**SUBJECT: Monument Academy – Construction Drawing Review
Response to County Review Comments
CDR-20-001**

In conjunction with our TIS, Roundabout Design Report, and Construction Drawing resubmittal, this letter provides responses to the review comments detailed in the Memorandum from PCD-Engineering dated February 6, 2020. These review comments are specifically addressed as follows (**Applicant responses are annotated in bold / red / parenthesis following each County comment**):

PCD Memorandum dated February 6, 2020

PP2

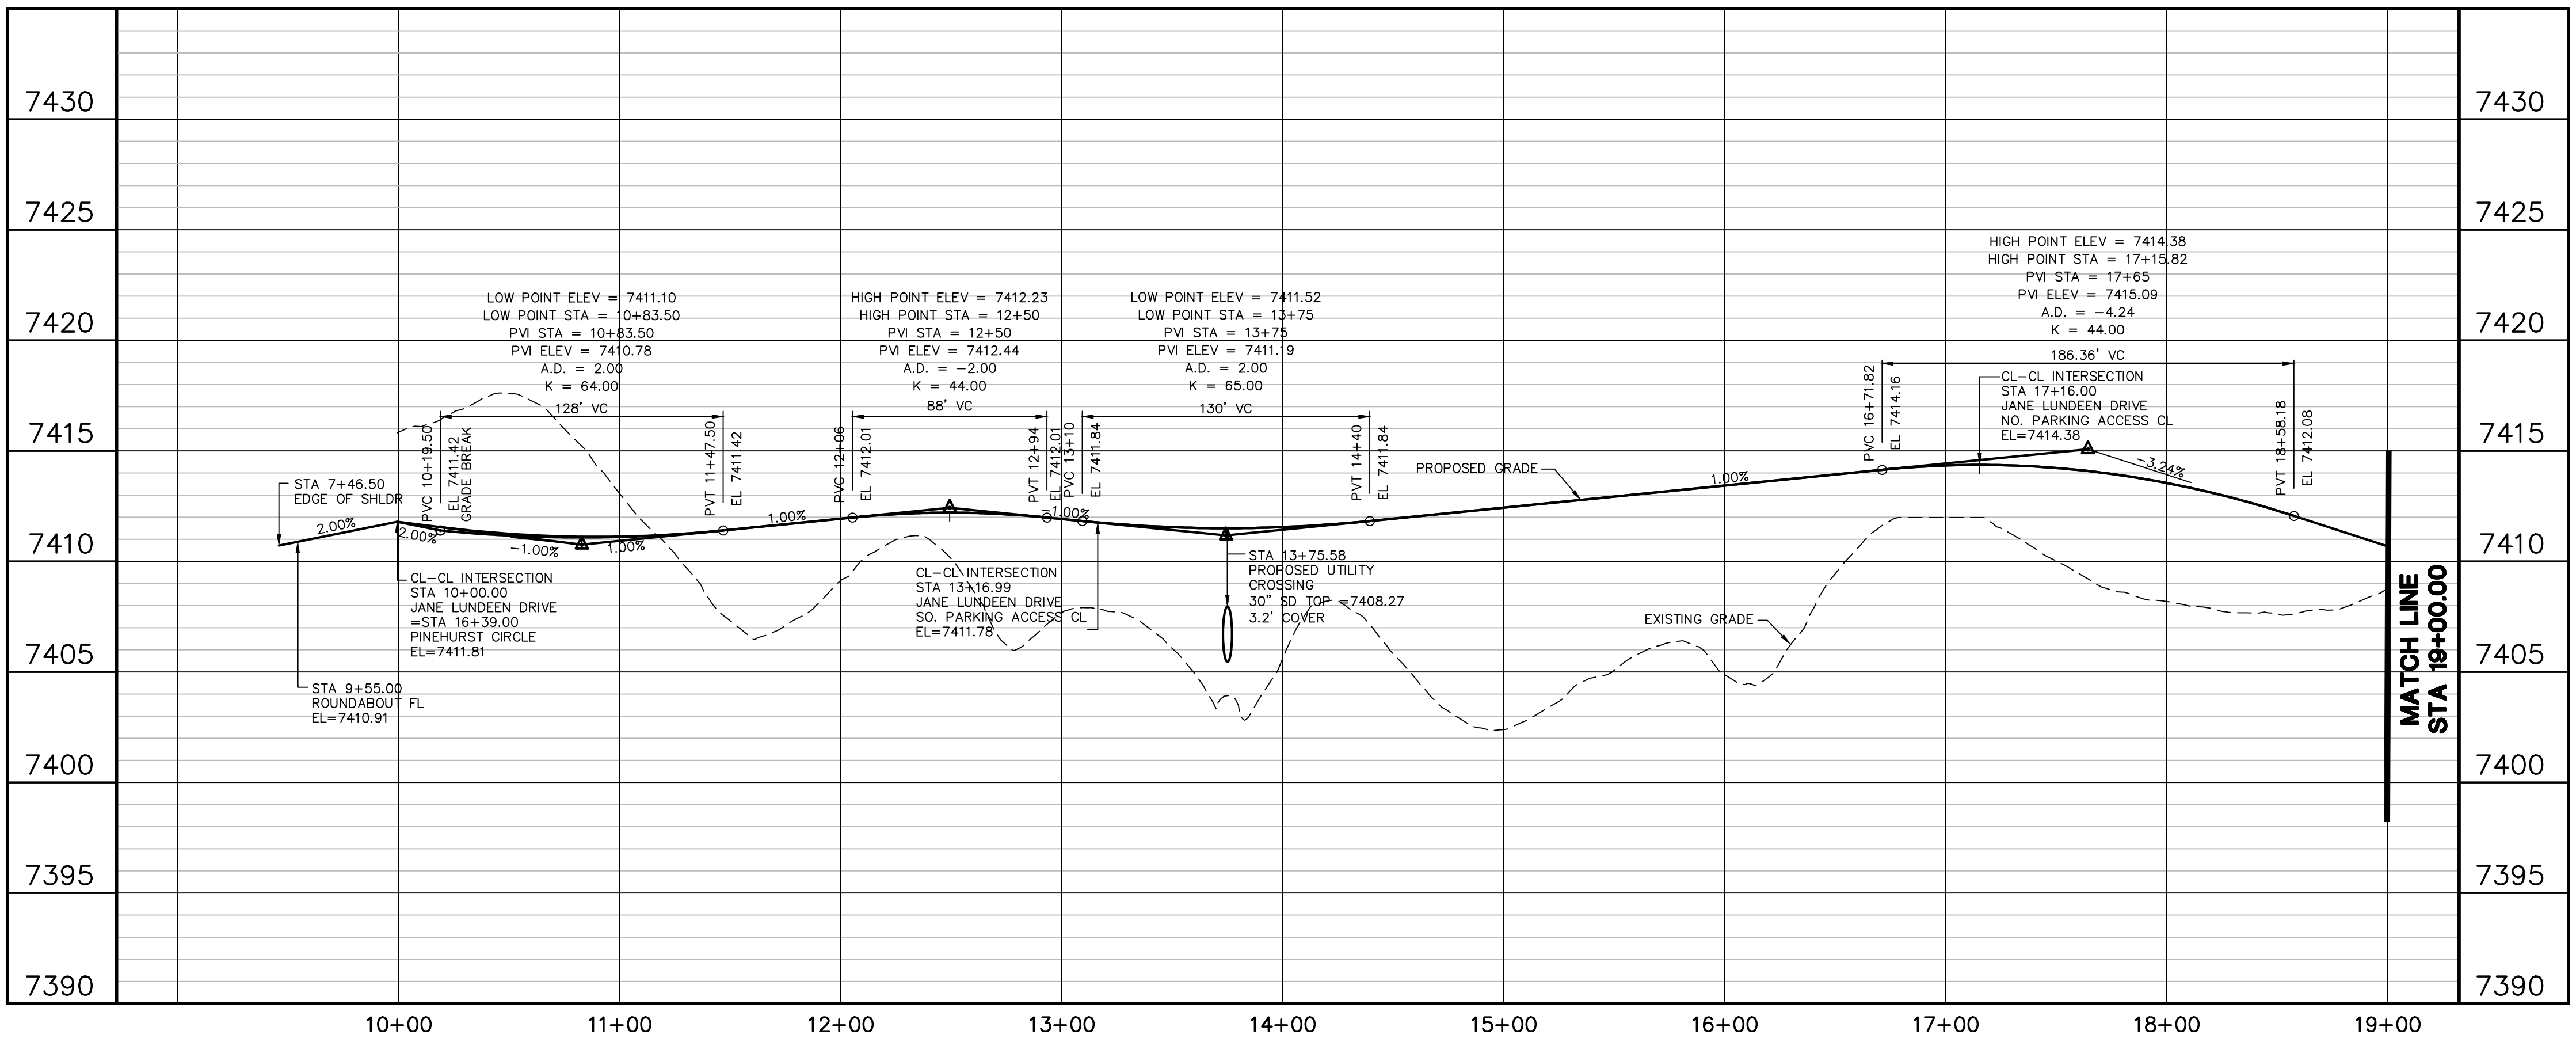
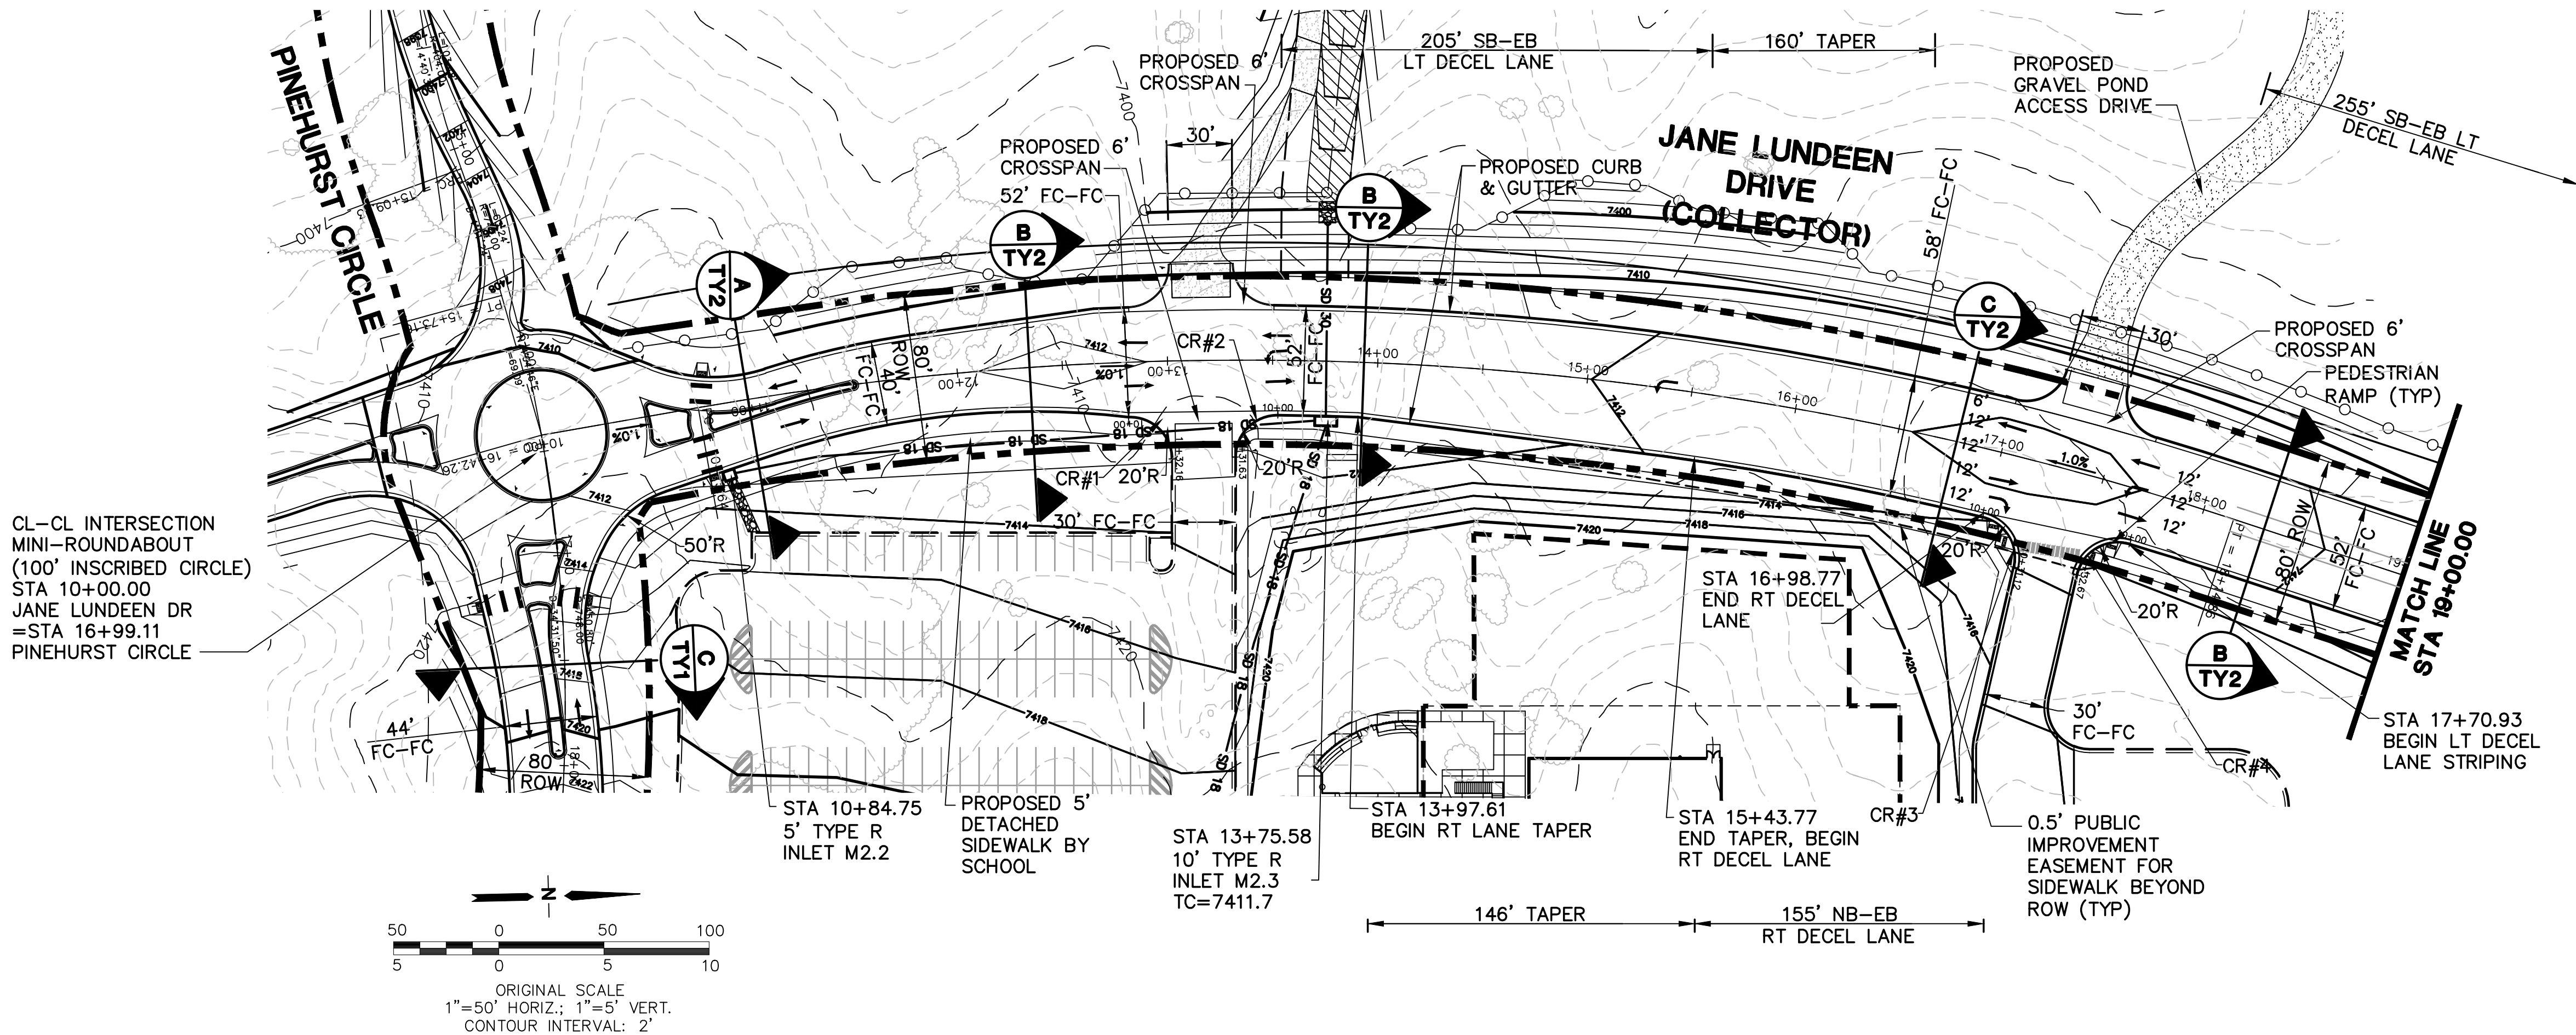
7. Provide complete construction plans including ROW/easement plans for the roundabout, Walker Road shoulders and ditches and the proposed relocation of Shannon Road to the west. Unresolved. ***For the purposes of Phase 1B, the proposed T intersection at Walker Road and Jane Lundeen Drive is being preliminarily reviewed. (See updated Roundabout Plans in CD's)***

- a. ***See deviation request comments above.***
 - b. ***The taper lengths should be based on at least a 45 MPH design speed.***
 - c. ***It appears that off-site easements will be required (on the north side) for the improvements along Walker Road. Show the easements on the plans, provide detailed grading plans and documentation from the property owners that they intend to grant the necessary easements.***
